Upper Lachlan Shire Council

Our Ref: F12/91

Your Ref: MP 10_0034

RE: SUBMISSION – CROOKWELL 3 WIND FARM – MP 10_0034

Figure 4: Proposed Access and Infrastructure Plan – Crookwell 3 South

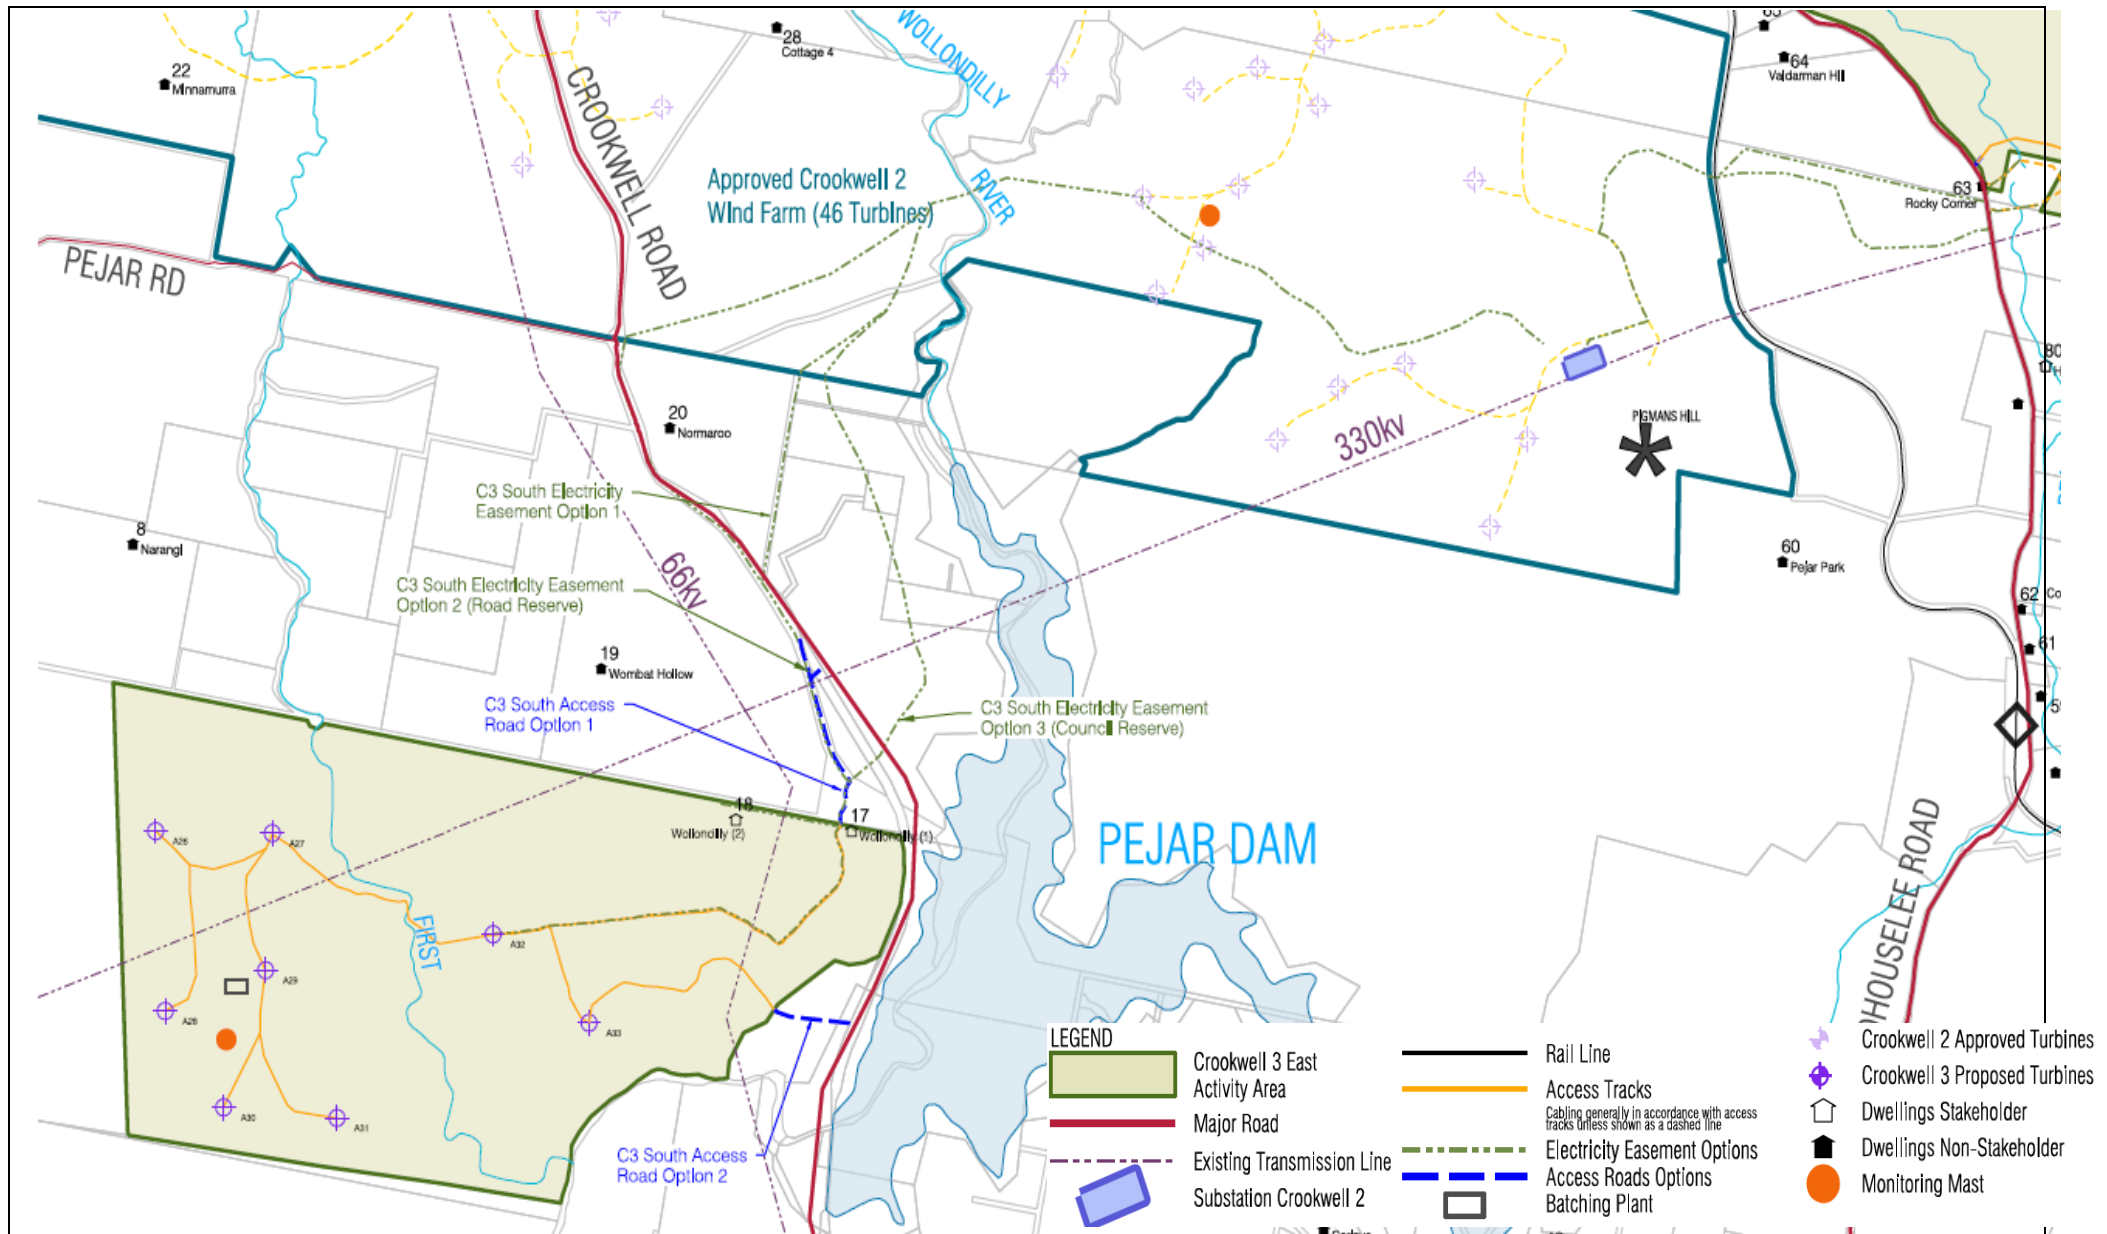
Council acknowledges that this part of the development will have access from Crookwell road (MR54) which is a state road. The applicant must seek approval from NSW Roads and Maritime Services for the proposed access. However, the following issues will be required to be addressed:

- a) Access – both options shown on the drawings involve difficulties with a lack of available sight distance. Whilst Council prefers the location shown as option 2 on the drawings, the proponent must provide additional information in relation to available sight distance (including the works that may be necessary to ensure that adequate sight distance exists). The proponent will be required to provide design drawings for the construction of the chosen access.

Figure 5: Proposed Access and Infrastructure Plan – Crookwell 3 East

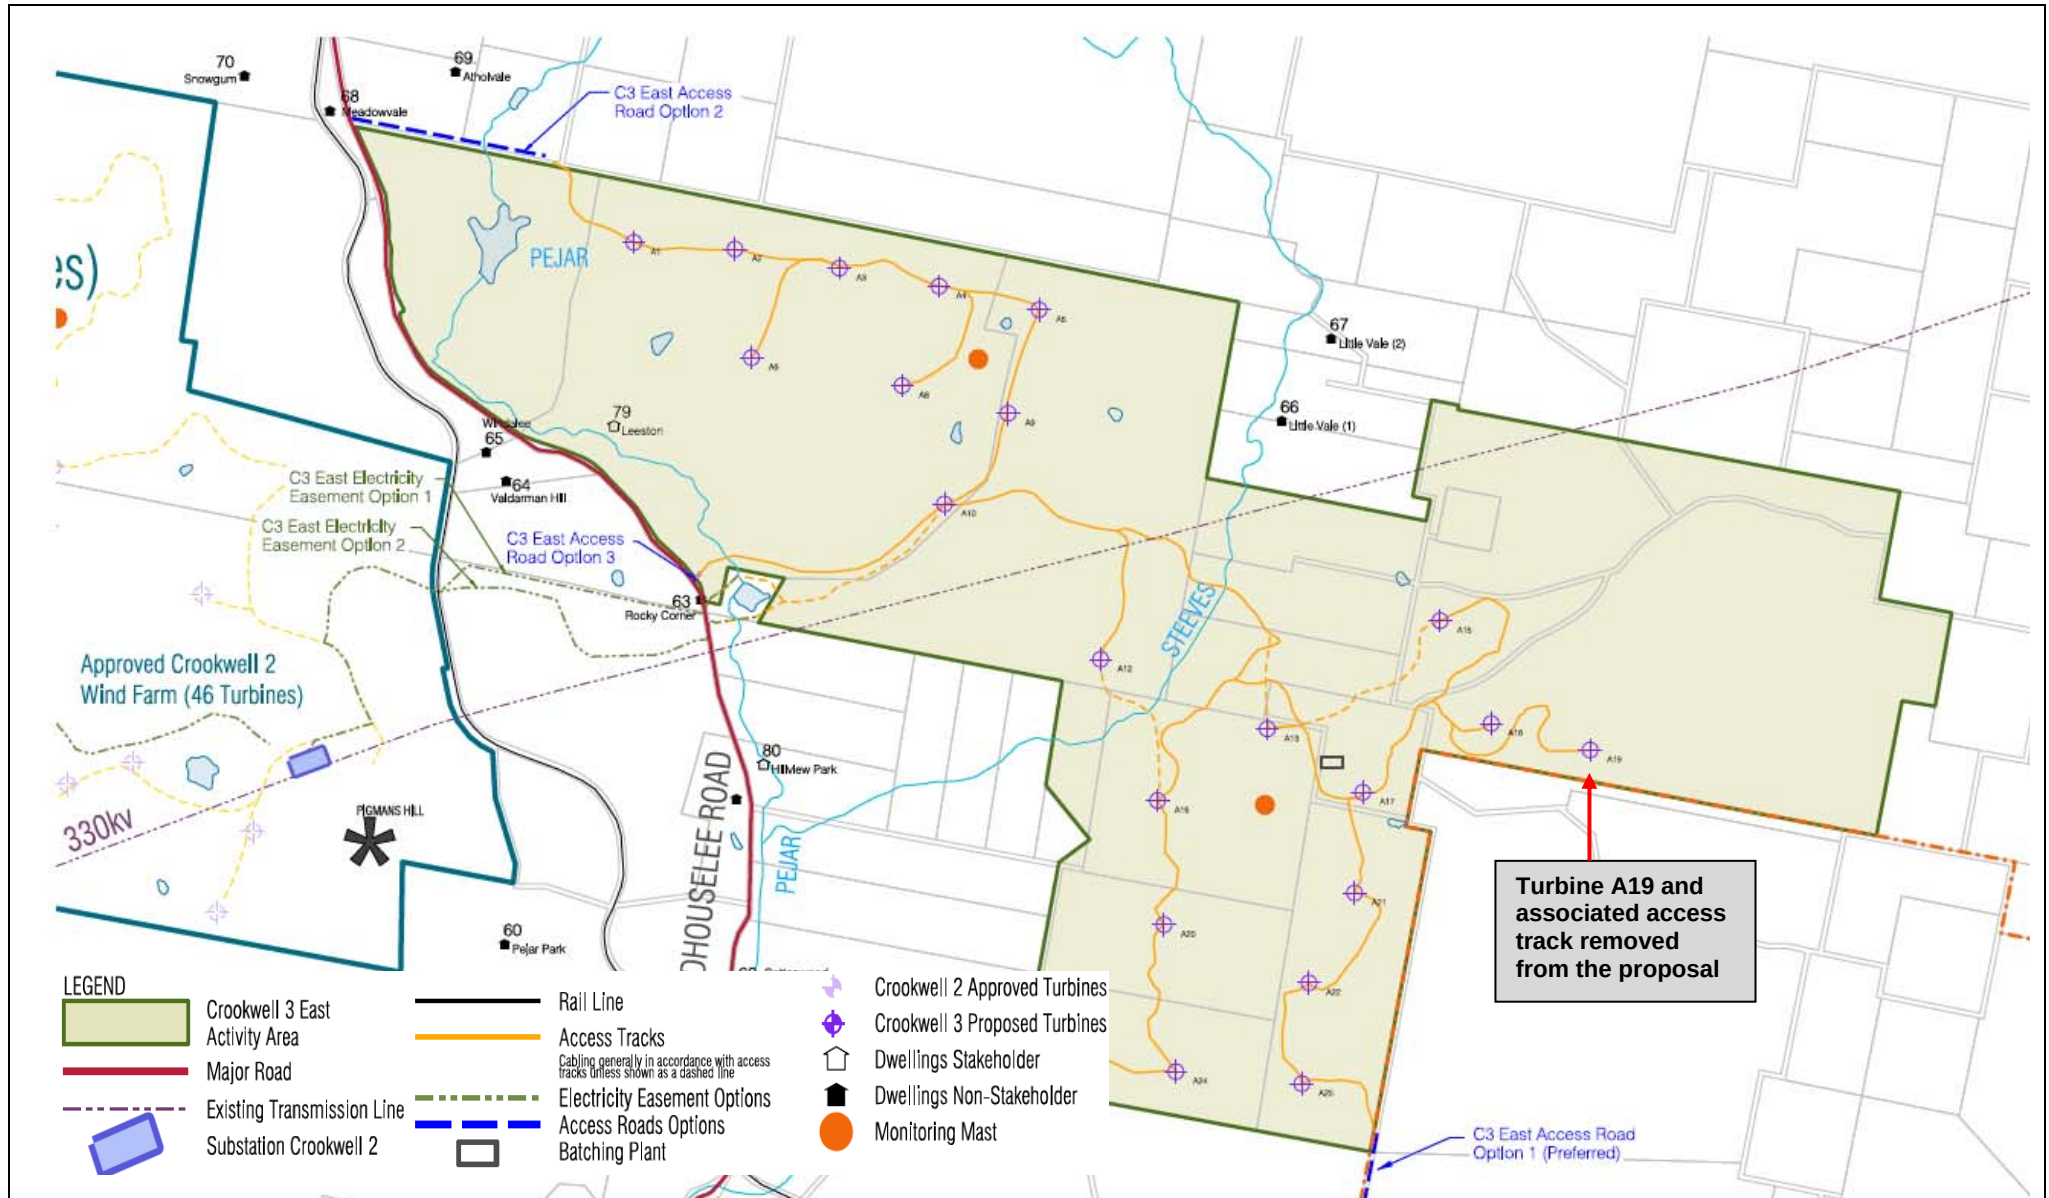
Council advises that all accesses shown on the drawings involve the creation of an intersection with Woodhouselee Road which is a Council owned public road. Upper Lachlan Shire Council is the owner and designated road authority (as described in the NSW Roads Act) for this road. All connections and intersections involving Woodhouselee Road must be approved by Upper Lachlan Shire Council prior to construction (by way of a permit issued under section 138 of the Roads Act) and prior to use. It should also be noted that Woodhouselee Road is a significant school bus route.

- a) Access - Council notes the access options shown on figure 12 of the drawings and advises that it favours the use of option 1 (it should also be noted that Council requires the applicant to use only one access from Woodhouselee Road to the development). However, the following issues must be addressed by the applicant.
 - 1. Greywood siding road is an unformed track for its entire length. The road is also a NSW crown owned public road (requiring arrangements to be made with NSW LPI regarding its use). The proponent will be required to construct the road for entire

length to a width of 8m, having a longitudinal and transverse design capable of accommodating the mass, length and width of vehicles required to service the construction and maintenance needs of the development. The design of the road will also need to adequately cater for stormwater issues created by the construction of the road at each of its low points and also for an intersection with Woodhouselee road that safely caters for the over dimension loads that are anticipated to access the development.

Should the applicant not use the access option 1, Council will require significant upgrading of Woodhouselee Road in the vicinity of Woodhouselee village to strengthen the pavement to allow for the anticipated additional heavy traffic and minimise nuisance to the residents of the village.
